Environmental and Animal Defense

## EL PASO COUNTY PLANNING COMISSION RESPONSE AND COMMENT TO PROPOSED PUDSP

November 4, 2019

PRELIMINARY GRADING & UTILITIES PLAN

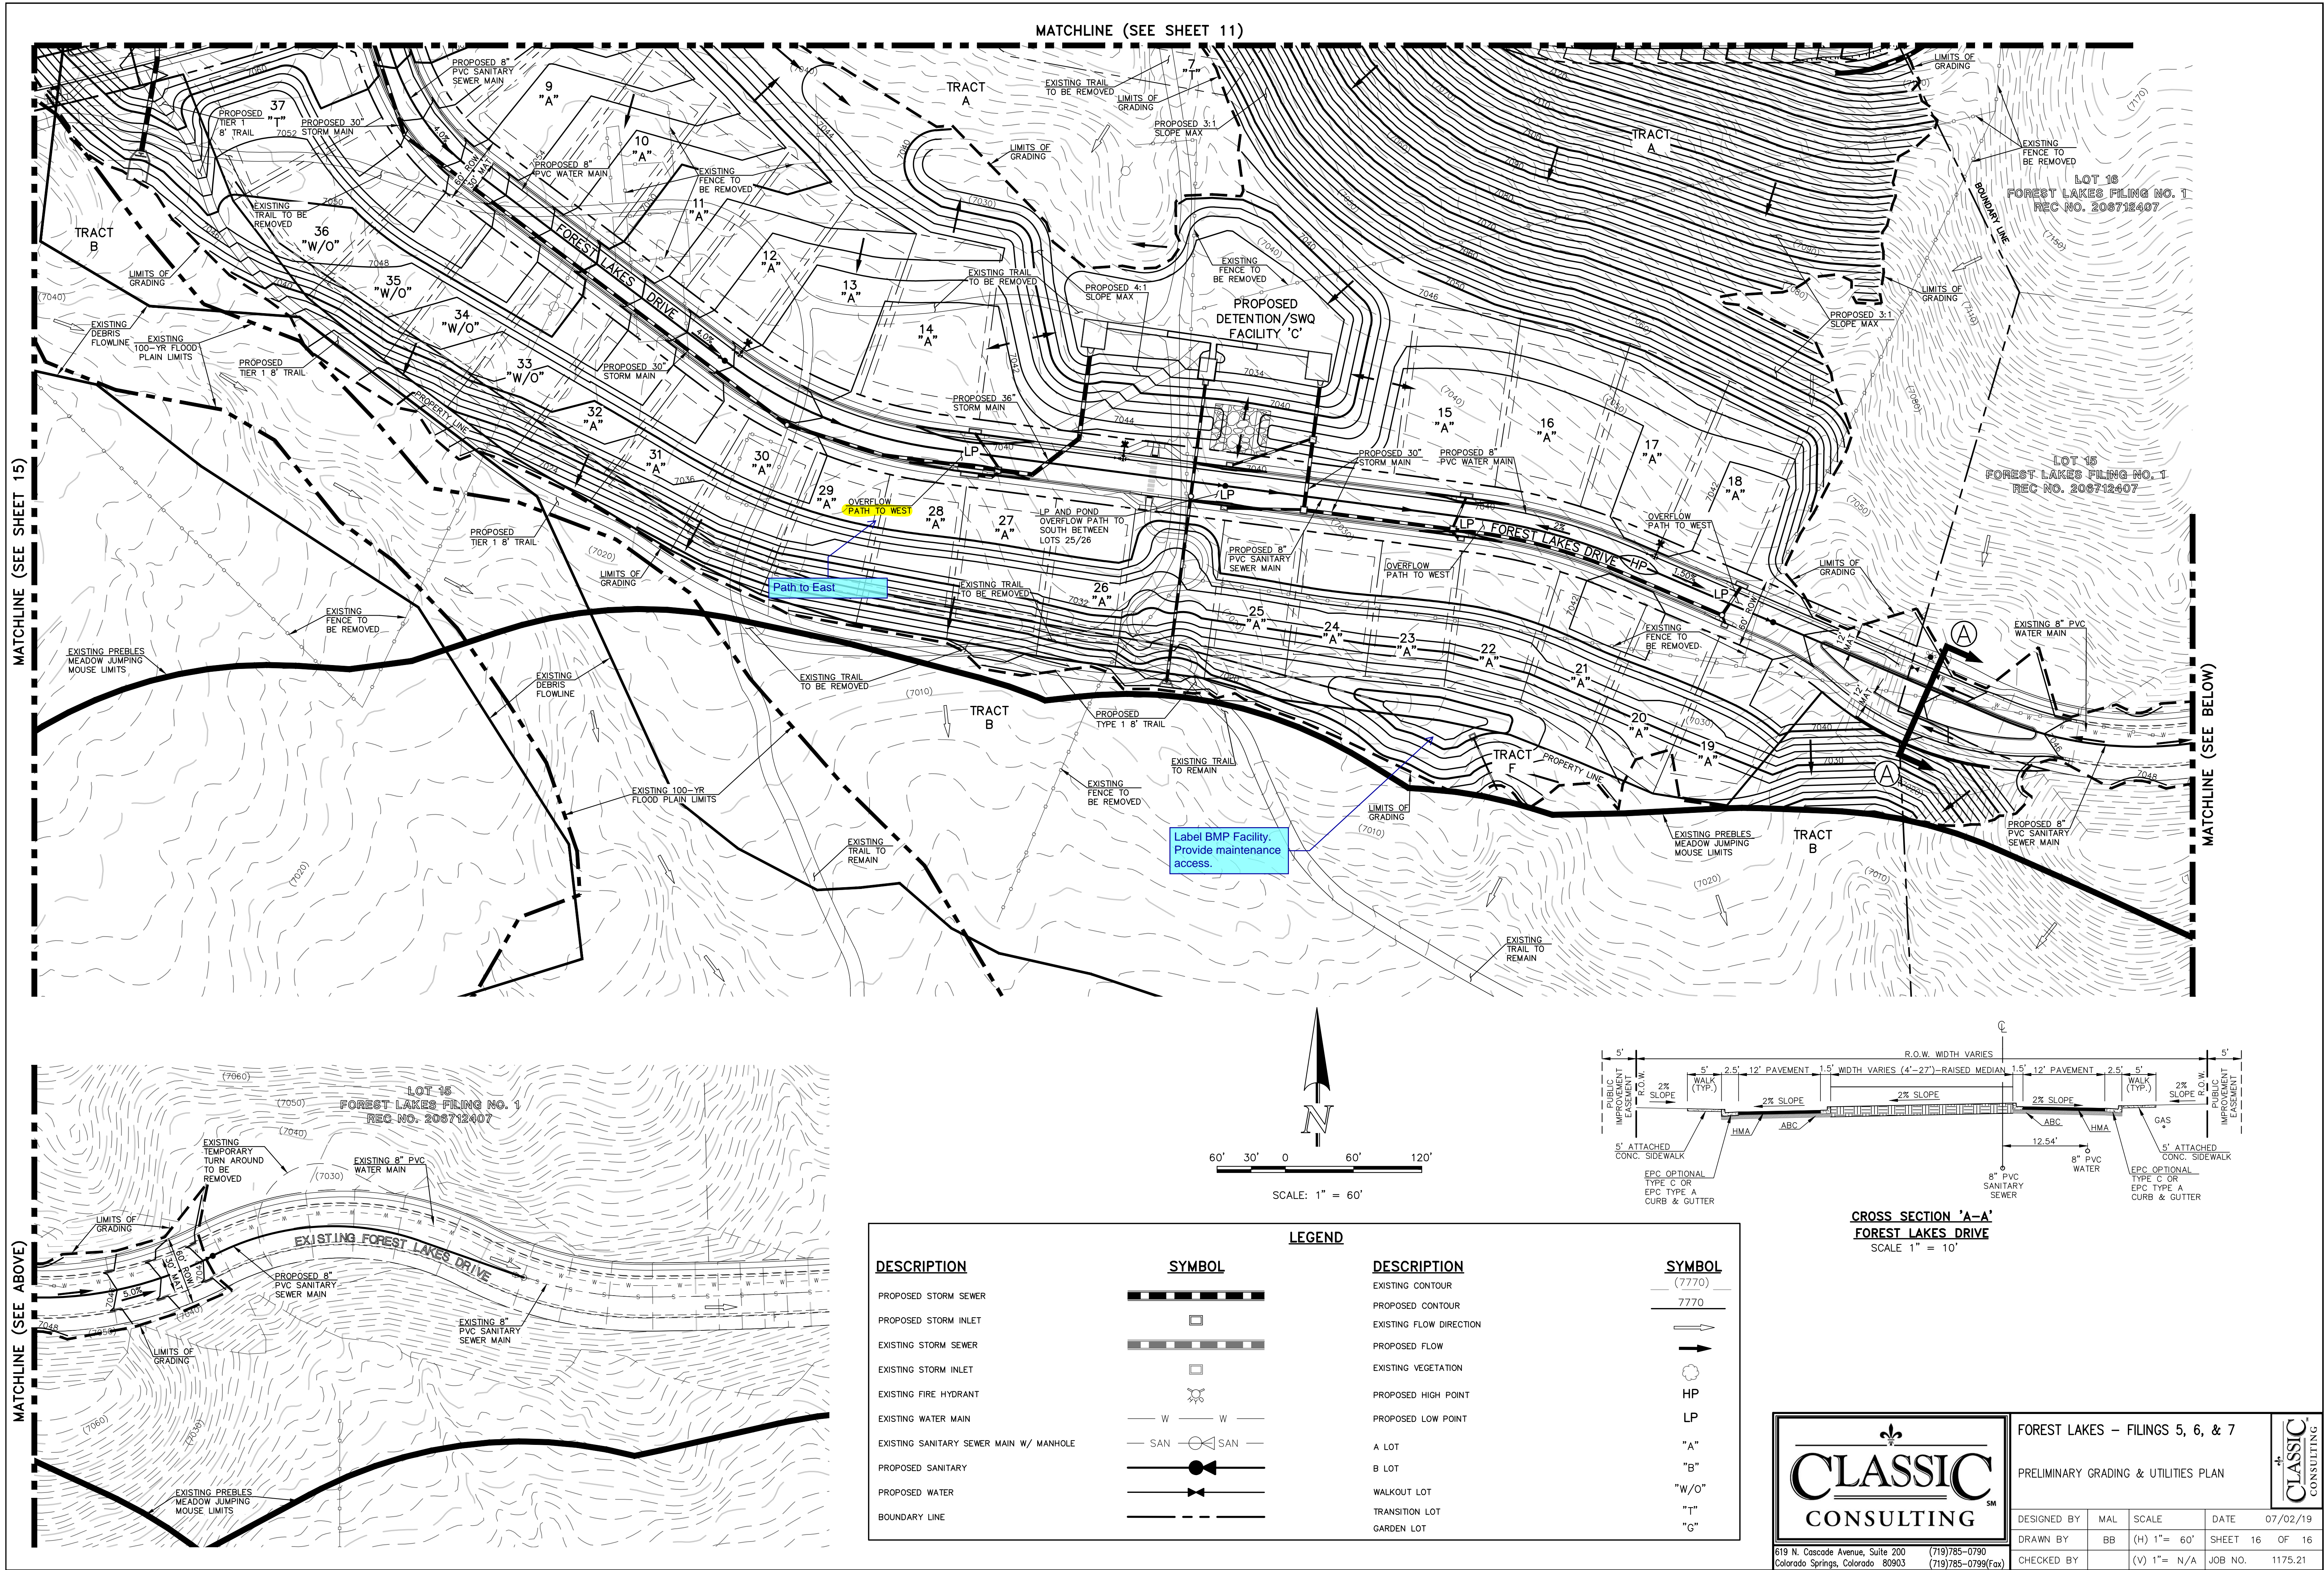
The applicant's current planning documents still show planned grading into the critical habitat zone, which was unreferenced by the applicant and FWS clearance letters. We pointed out that applicant's plans showed grading into the critical habitat in our previous comment letter.

We provided the map overlay marked as Figure 2 that showed there were several points in which proposed grading will cut into the Preble's Meadow Jumping Mouse critical habitat zone. We stated the proximity of homes to the critical habitat boundary presumably created the necessity of grading into the critical habitat zone.

Applicant has since revised their grading lines in their current submission to remove these grading lines from the critical habitat zone. Applicant's plans now also omit grading lines that were present in the original application by simply cutting off the line where grading would seemingly, by necessity of the plan, extend into the critical habitat area.

DESIGNED BY	MAL	SCALE	DATE	10/24/18
DRAWN BY	BB	(H) 1" = 60'	SHEET	15 OF 16
CHECKED BY	(V)	1" = N/A	JOB NO.	1175.21

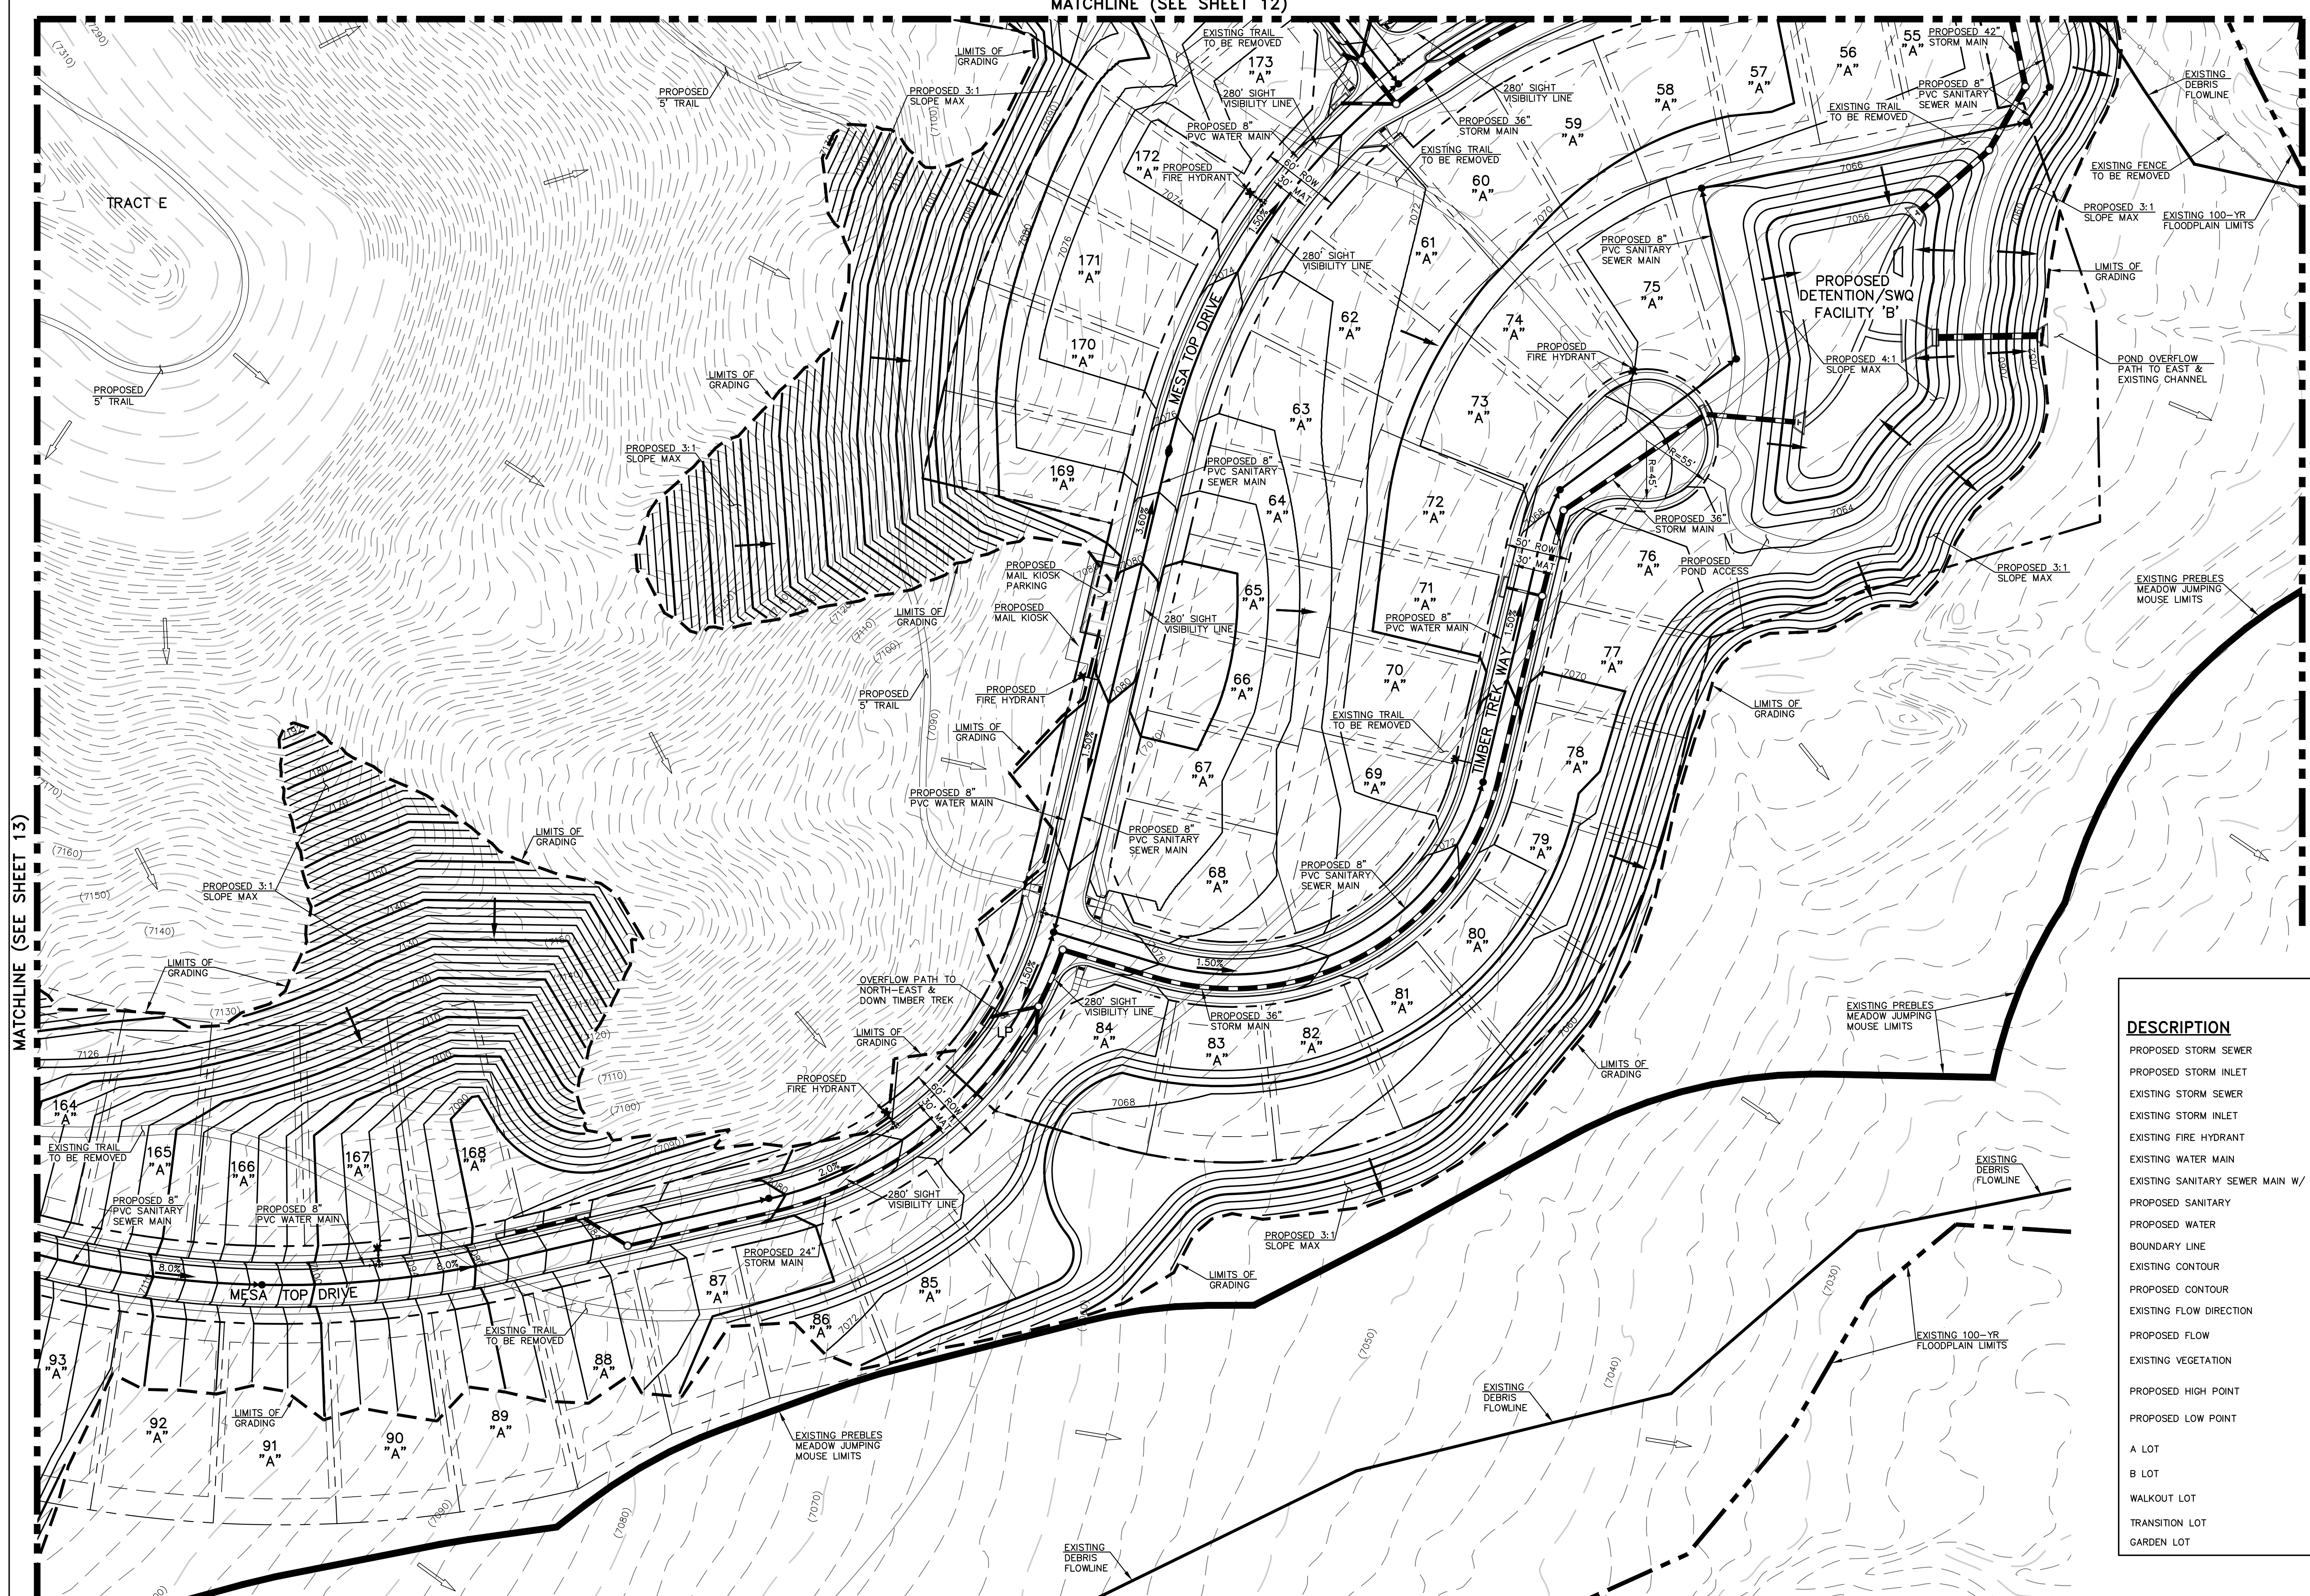
Applicant implicitly acknowledges misrepresenting their plans to this commission in previous hearings by correcting or omitting the grading lines in their current submission.
